From: Philip Woolger [REDACTED]
Sent: 27 October 2020 12:34
To: Kathryn Welch <Kathryn.Welch@arun.gov.uk>
Subject: RE: 8 Fernhurst gardens.

From: "Kathryn Welch" <Kathryn.Welch@arun.gov.uk>
To: "Philip Woolger" [REDACTED]
Sent: Tuesday, 27 Oct, 20 At 10:51
Subject: RE: 8 Fernhurst gardens.

Drawing no.003
Date 27/09/20
Issue 02 NTS
Dimensions added

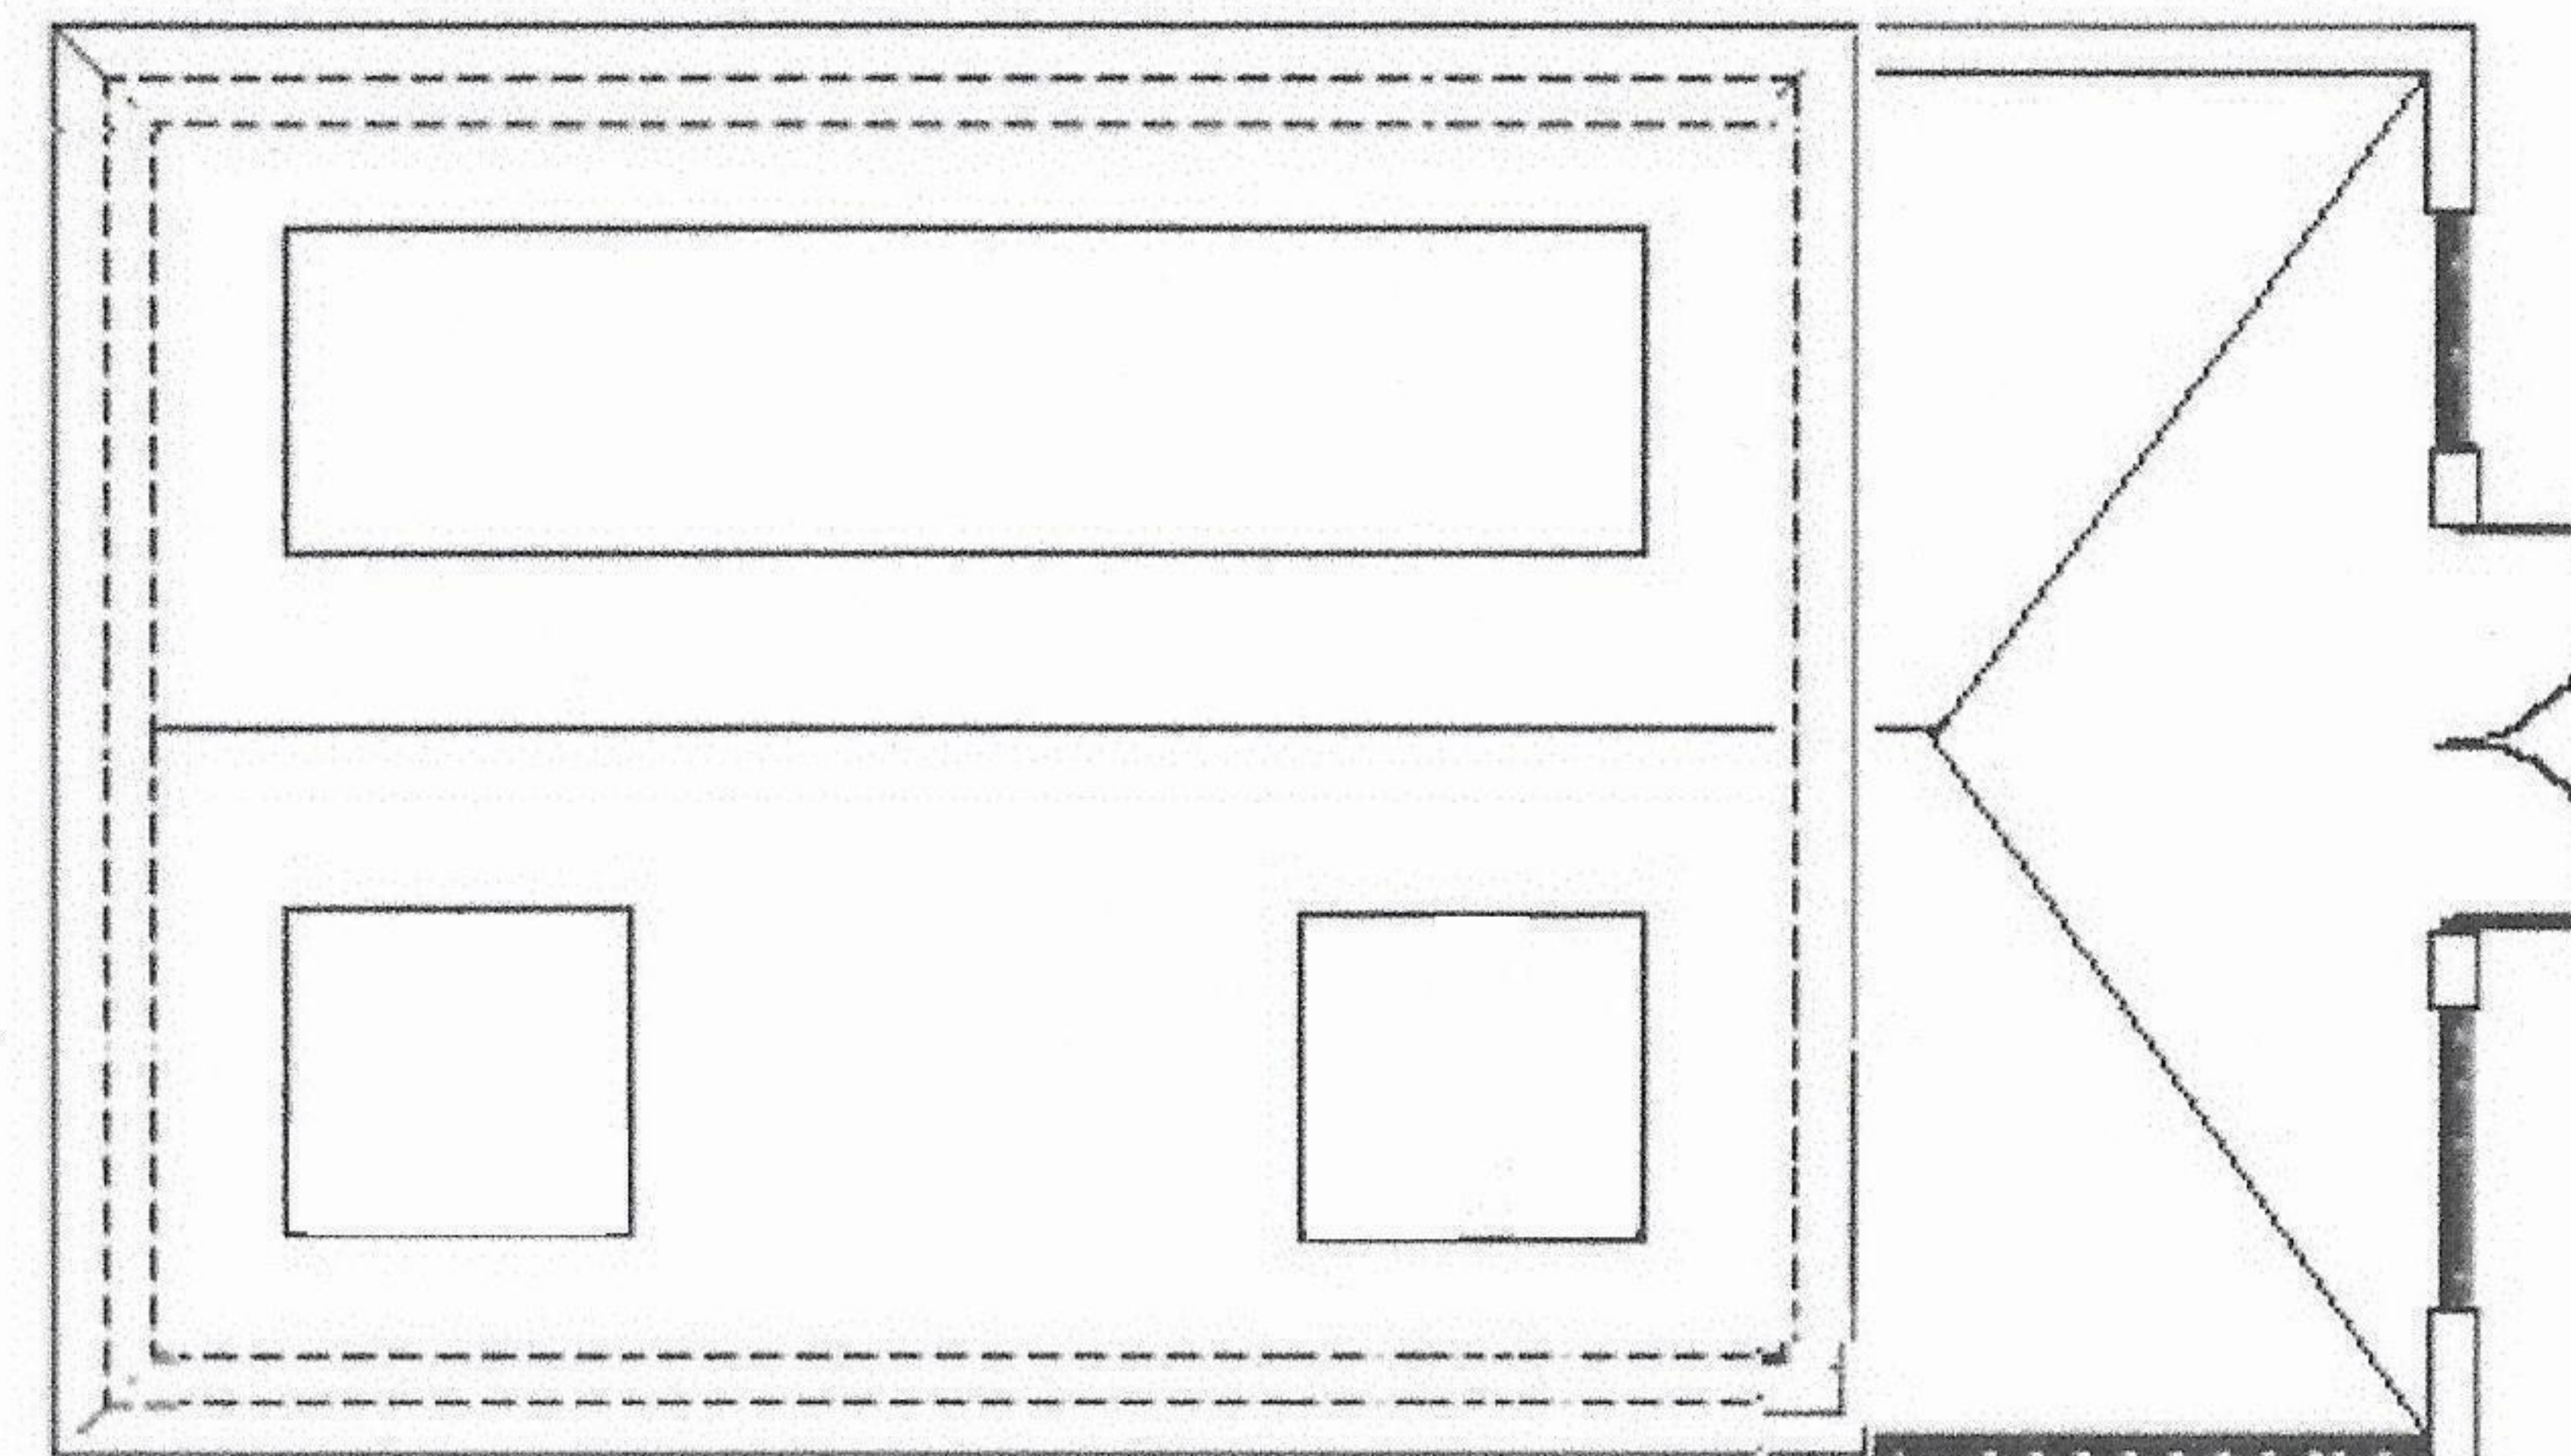
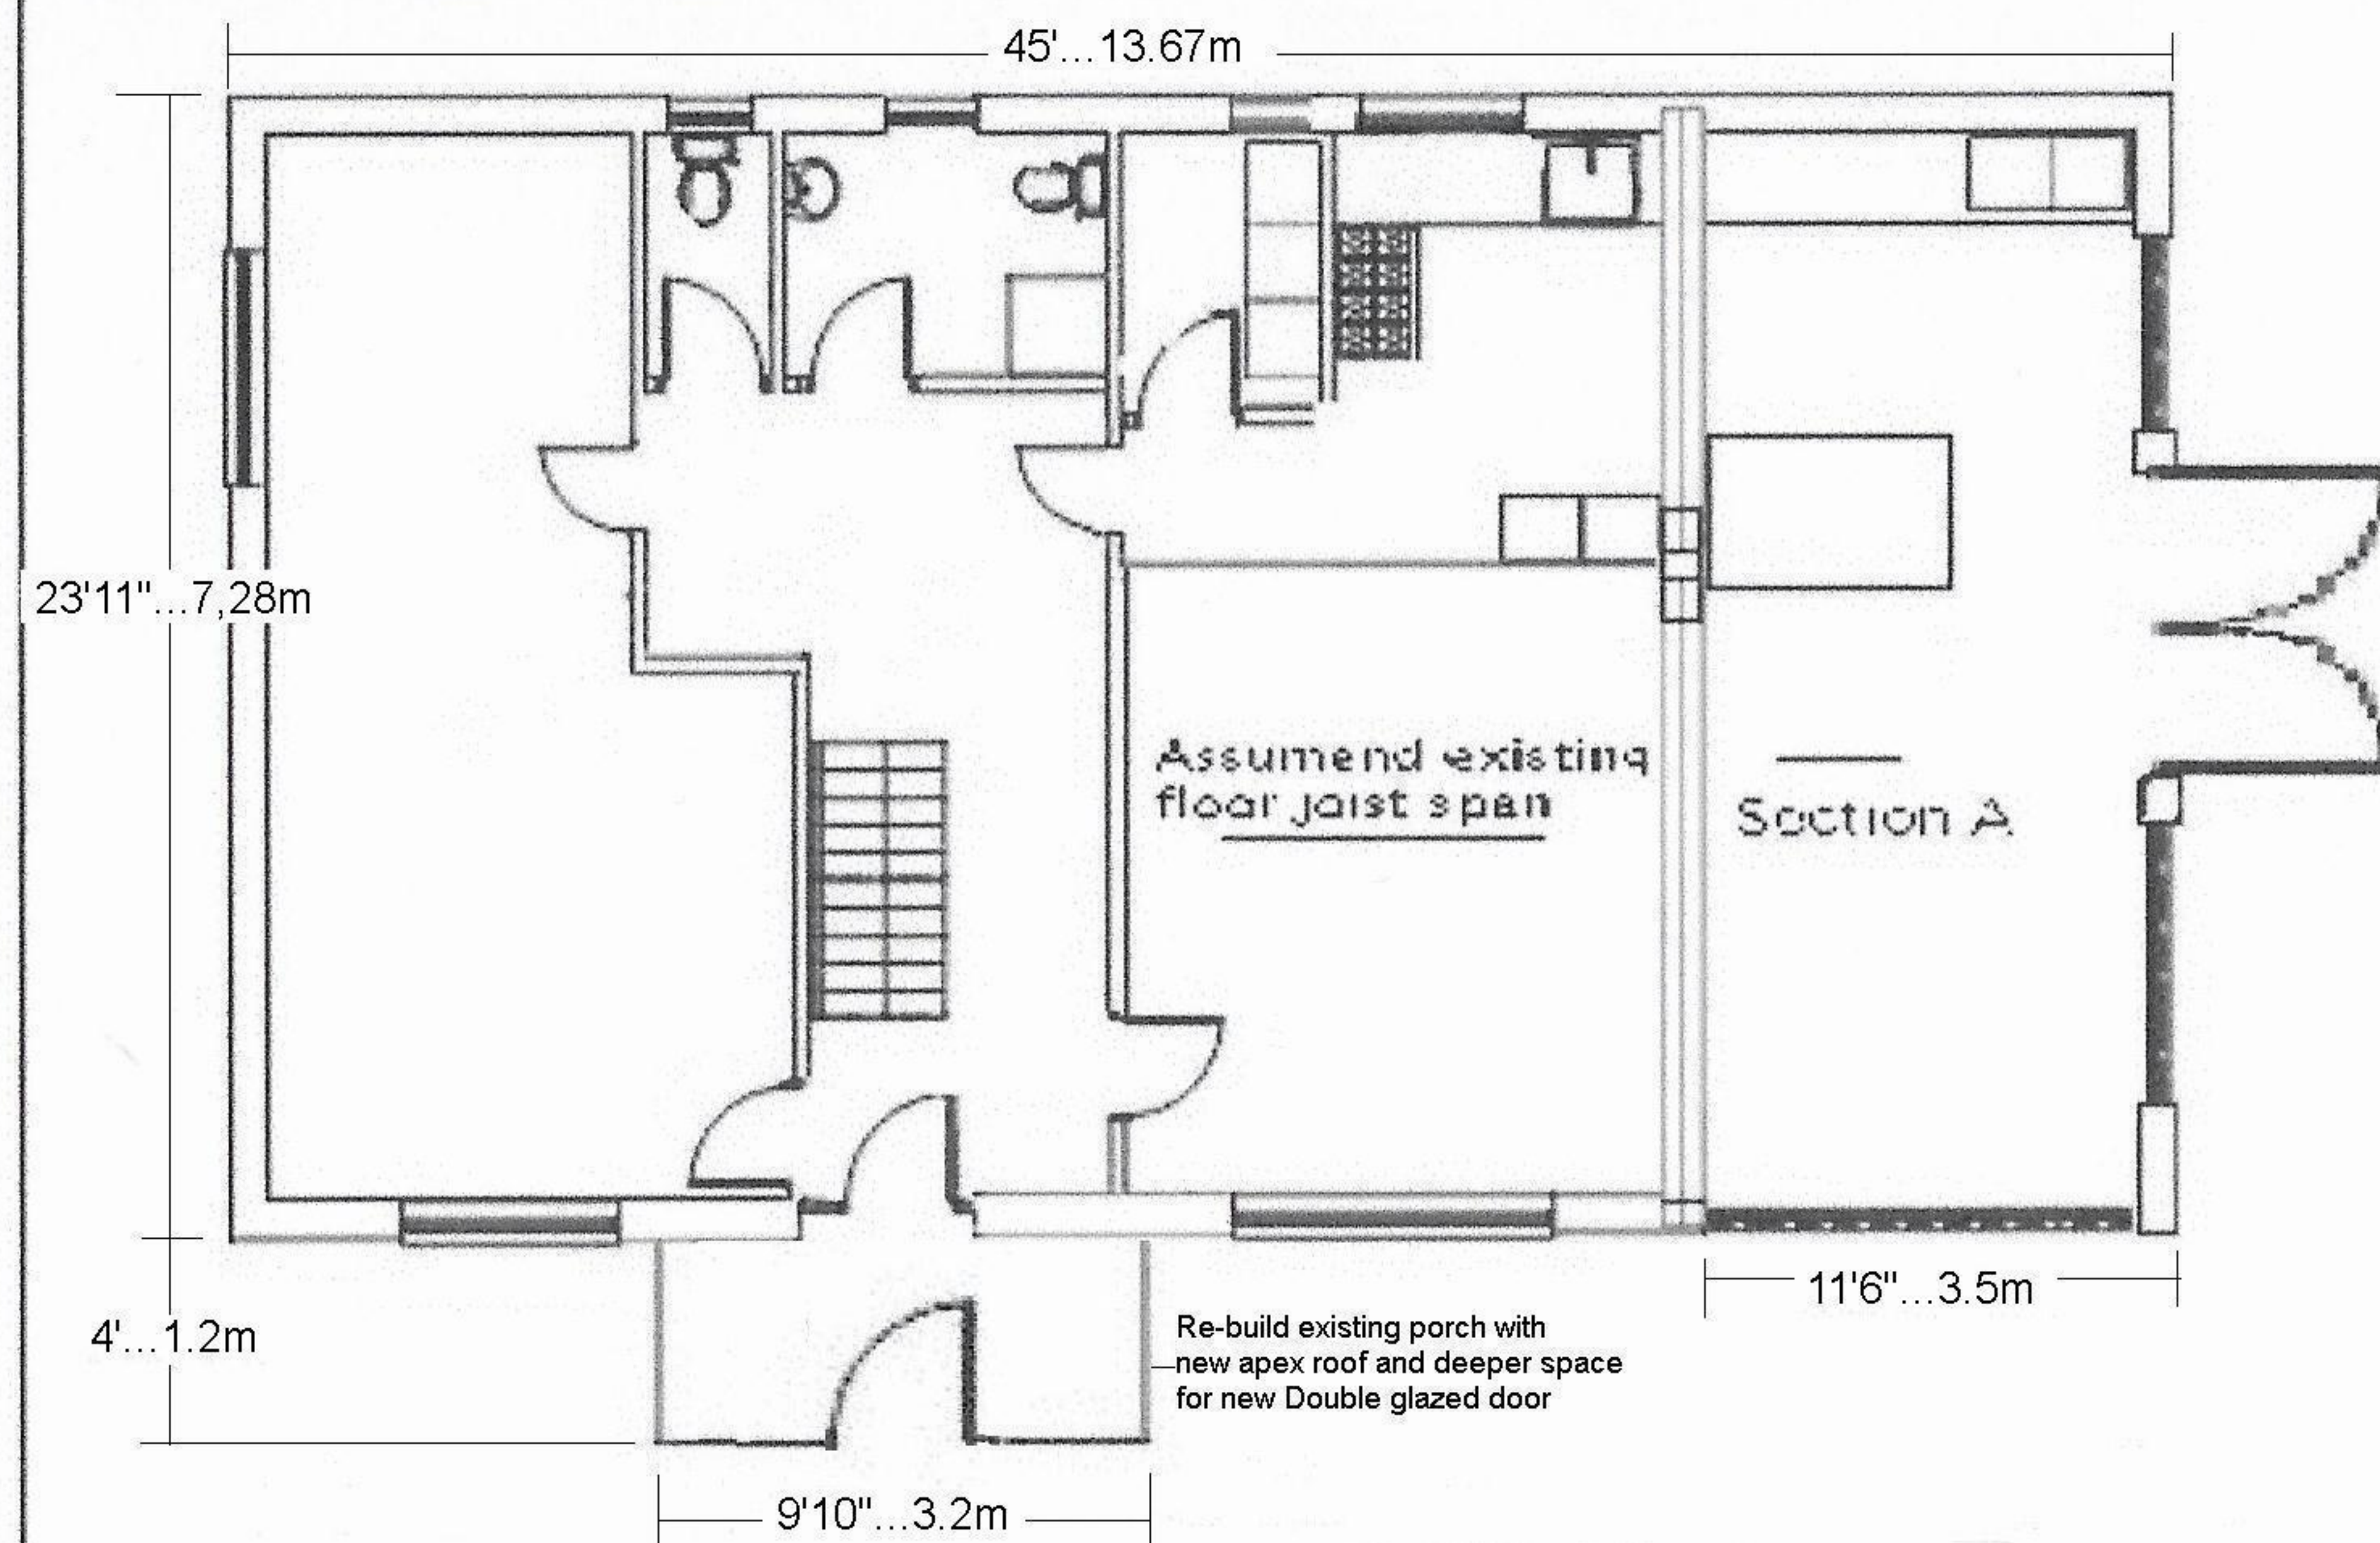
- The porch is slightly too large, to be covered by PD rights the maximum allowance is 3m² and your proposal currently measures at 3.84m² can you adjust this on plans 010 and 003.
- Can I have confirmation of the height to the eaves for the extension, either via email or included within a plan,
- Can you confirm that the extensions will be built of materials to match the existing property. You've noted a concrete slate tile on the roof of the extension; do you already have these on the existing house or can you amend to something similar to the existing,
- Can you confirm the proposed hardstanding for 2-3 cars will be built of either porous materials or will drain off to water permeable area within the site, again just a written confirmation will suffice.

porch 3m x 1m ...2.2m to eaves.....Antique red Marley plain tile 265 x 165mm as per existing building.....and Block paved driveway (we were planning on this)just missed it off. We understand about the drain off on solid concrete.

Attached drawing 003...and 010...adjusted .
